Re: Sound Management Plan

The Peer Reviewer is completing the review and has asked me to check with you regarding one piece of data that is fairly critical to the assessment.

The submitted East Tower building elevations show that the helipad is at 271' 10" above SL (see attached). However, the FAA Heliport Application states (box 9 on attached) that its at 240 feet elevation.

1/8" = 1'-0"

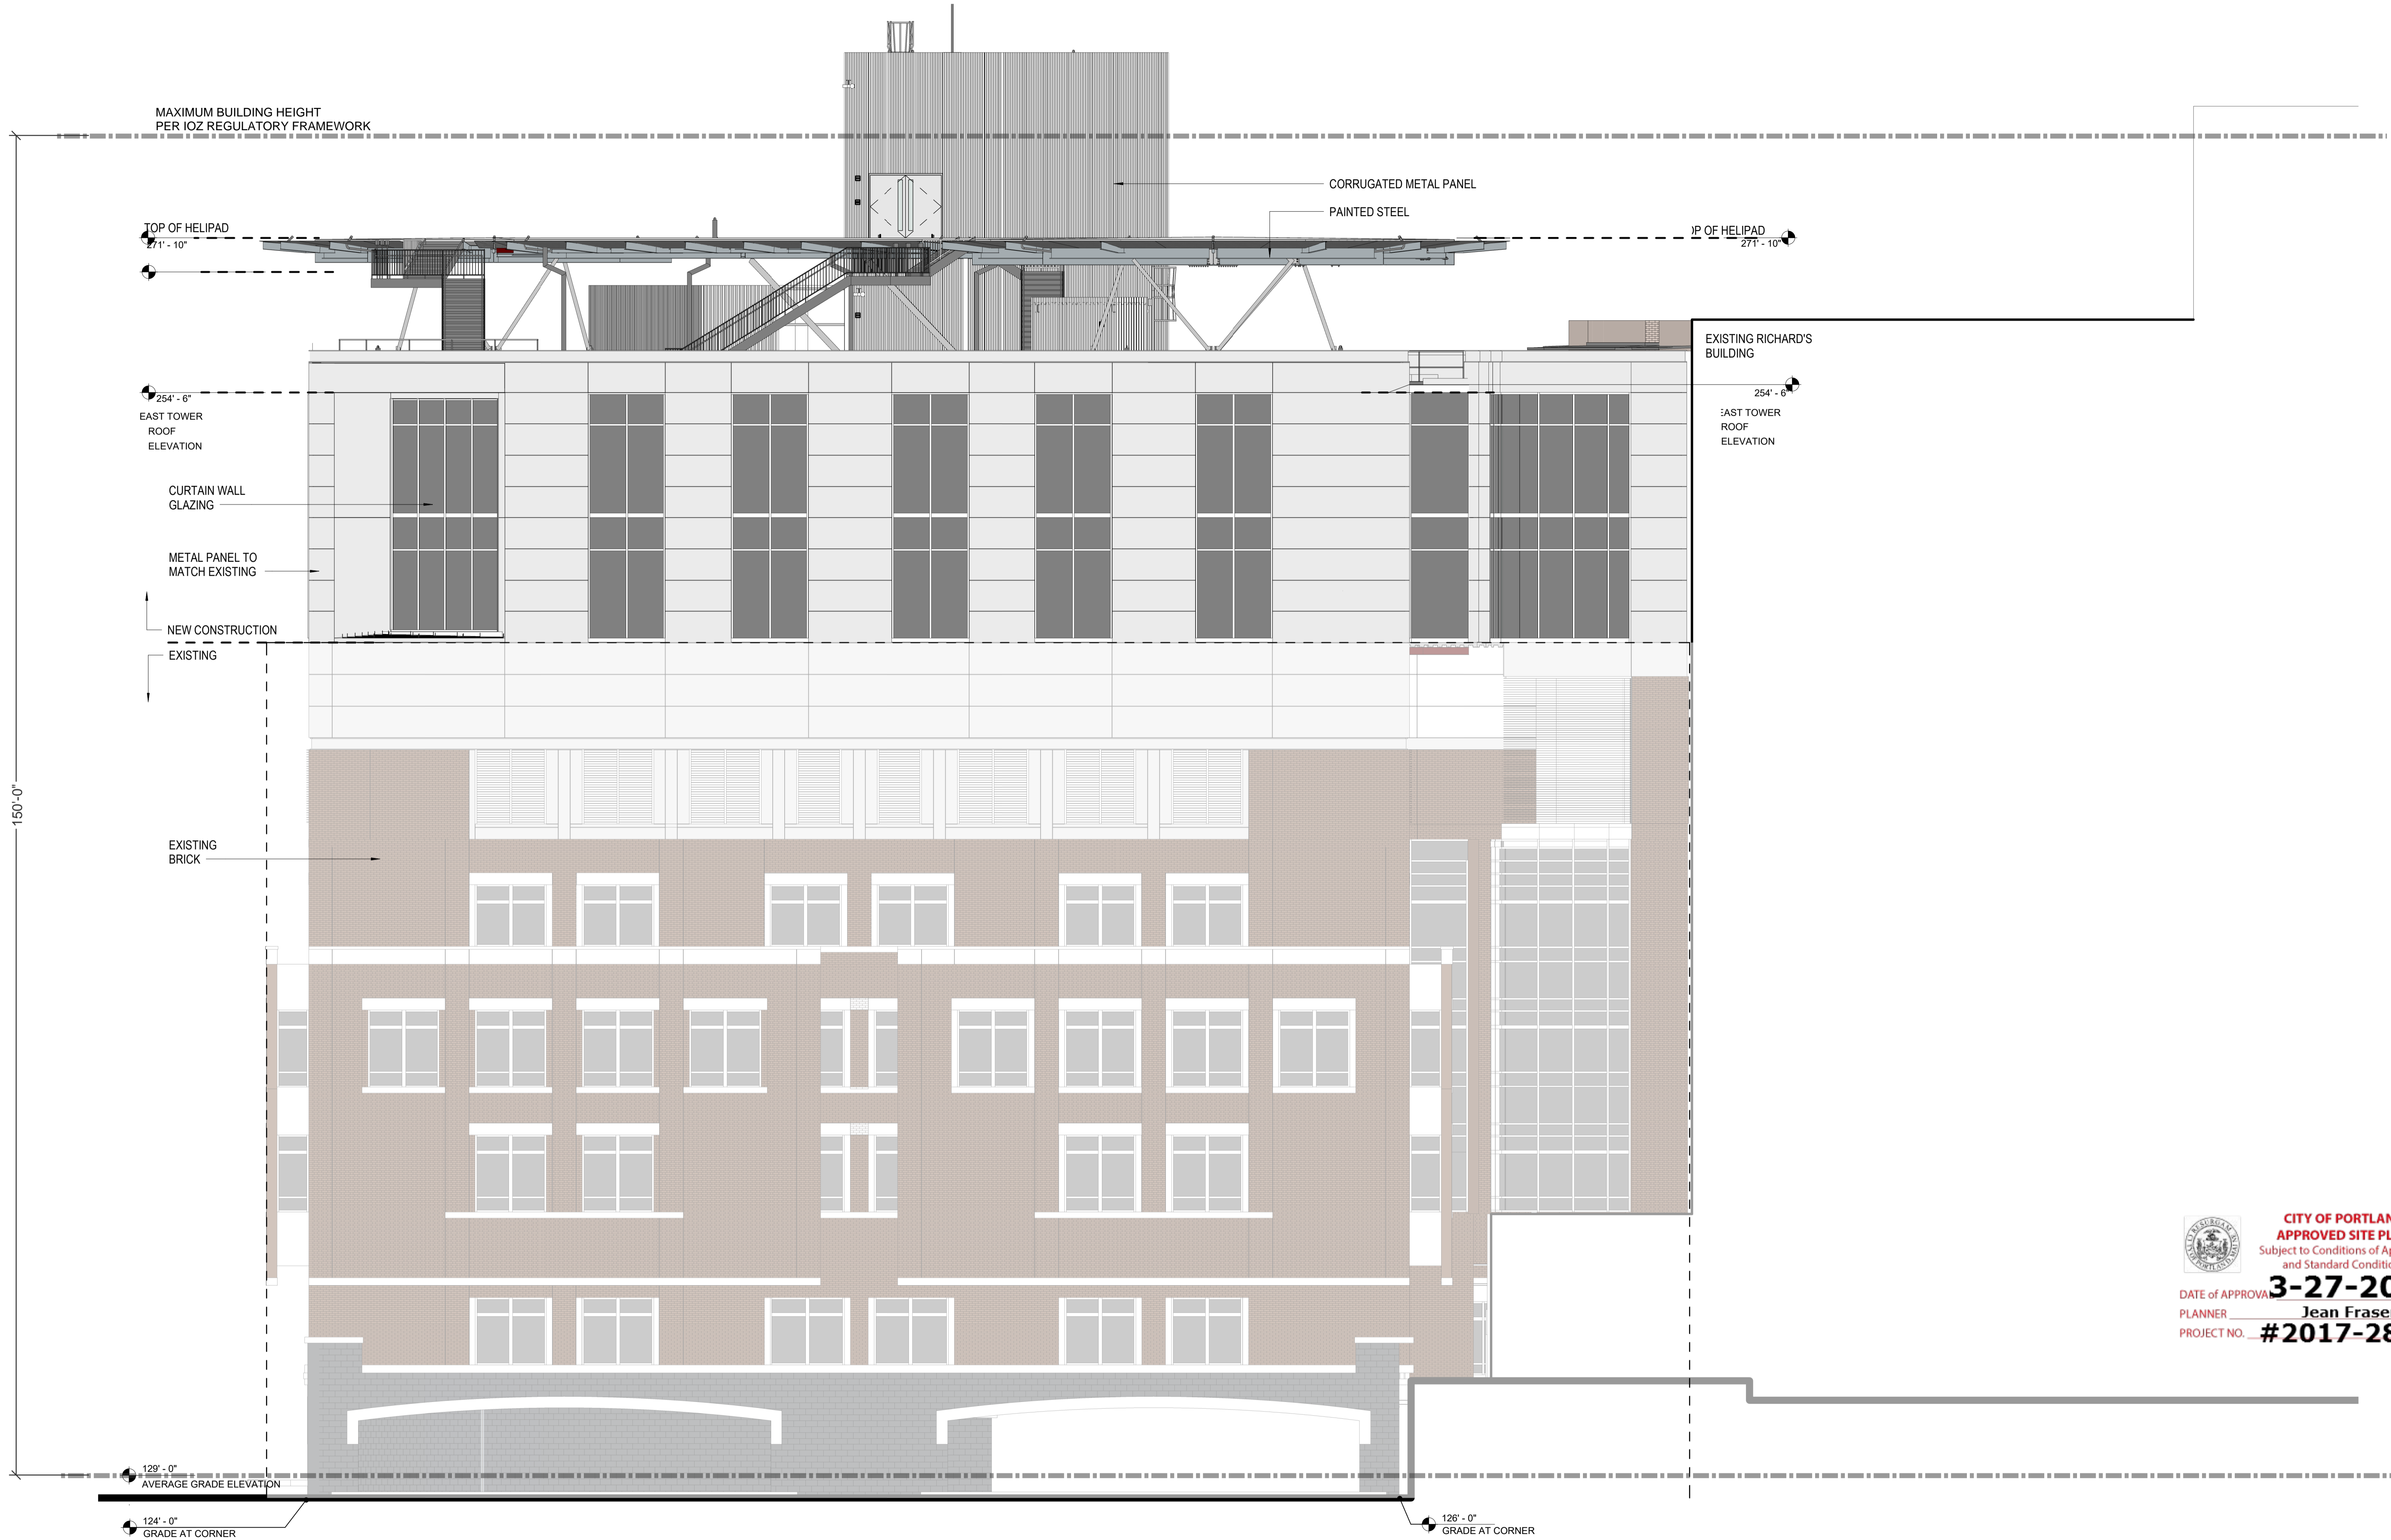
This difference of 30+ feet impacts the assessment and we would be grateful if you could confirm the correct elevation for the new helipad.
